**Re: SEVEN CLOVER DISPENSARY
3641 12TH NW
ALBUQUERQUE, 87122
Traffic Circulation Layout
Engineer's/Architect's Stamp 5/1/2024 (G14D062)**

Based upon the information provided in your submittal received 5/6/2024, the above referenced plan cannot be approved for Building Permit until the following comments are addressed:

CS-101

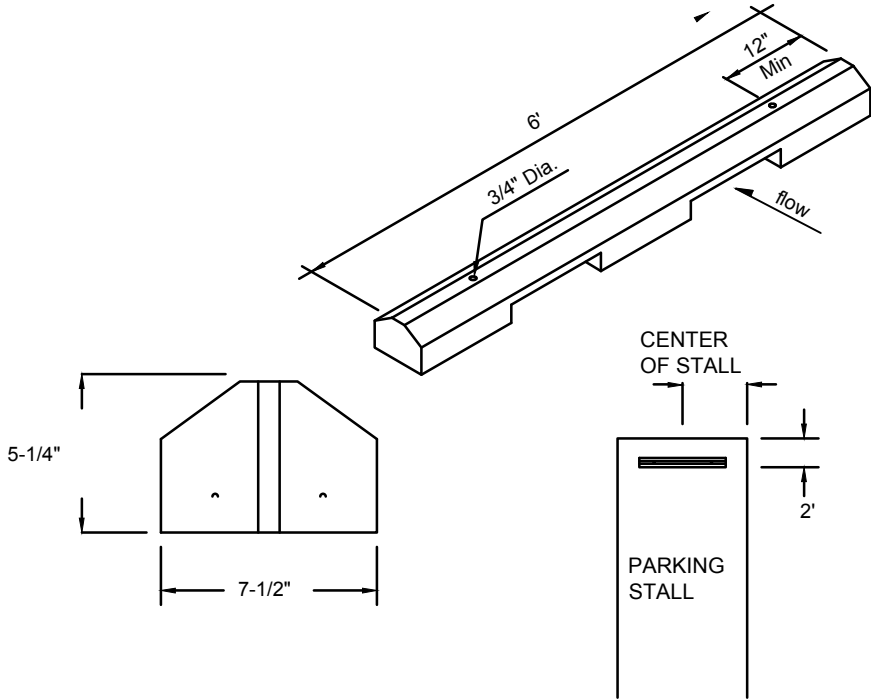
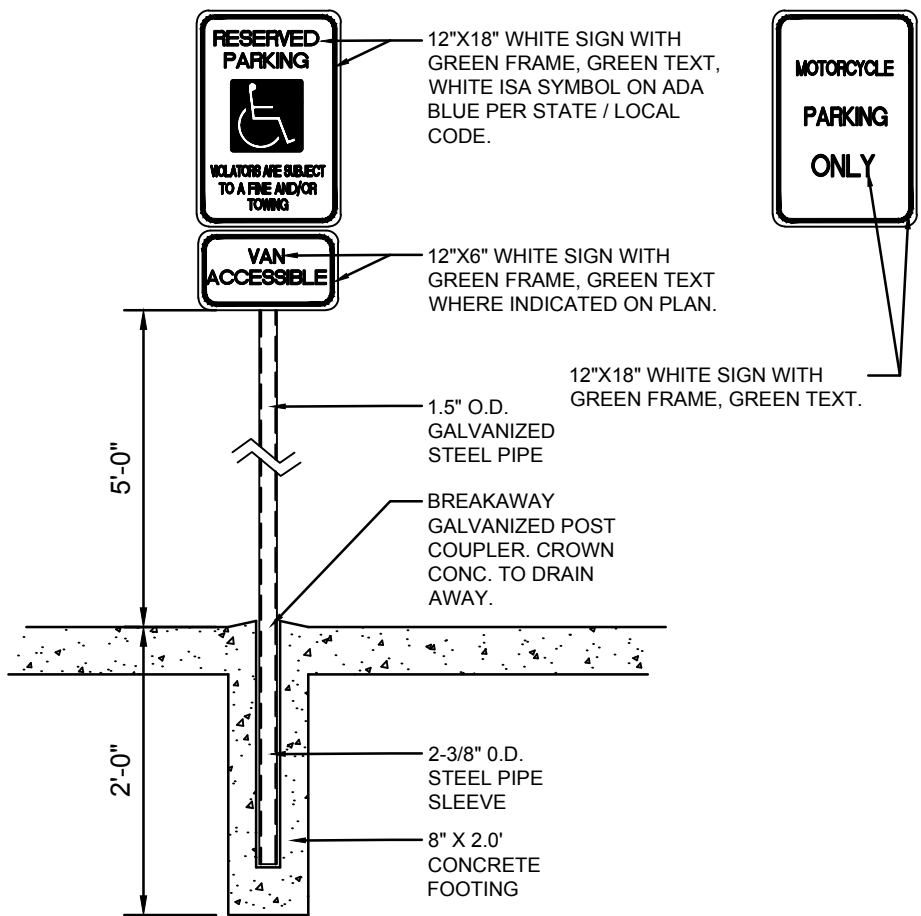
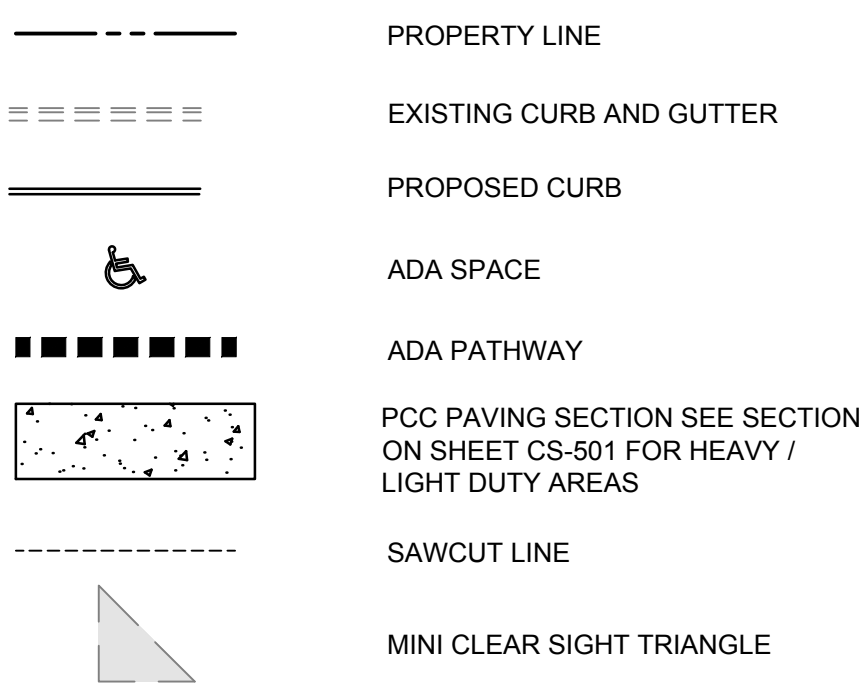
1. Show exiting, entrances, sidewalk, ramp and curb and gutter on the site plan.
2. The bike rack is too small. The rack shall be a minimum 30 inches tall and 18 inches wide.

3. Bicycle parking spaces shall be at least 6 feet long and 2 feet wide.

4. Show the clear sight triangle and add the following note to the plan: "Landscaping and signage will not interfere with clear sight requirements. Therefore, signs, walls, trees, and shrubbery between 3 and 8 feet tall (as measured from the gutter pan) will not be acceptable in the clear sight triangle."
5. Replace the 6" in the Keyed Note 19 by 8" curb, Curbs on arterial streets are usually 8" tall.
6. Provide Fire and Solid Waste Departments Approvals for the new layout
7. The Keyed note 1 don't point to anything. Please, move them to point to correct objects.

8. The 29.45' dimension for the east drive aisle and a the 37.18' dimension on the south side of the building do not point to anything on the east side.

9. The new sidewalk is to match the color of the existing sidewalk. Please Revise Keyed Note 4.

10. What is the "wider" hatching around the building supposed to represent?

11. Do you want the hatching between the accessible aisle and the door to be painted?

12. Provide the width of the sidewalk from 12th st onto the site.

13. Will the bicycle racks interfere with sidewalk usage for customers that park west of the accessible spaces south of the building.
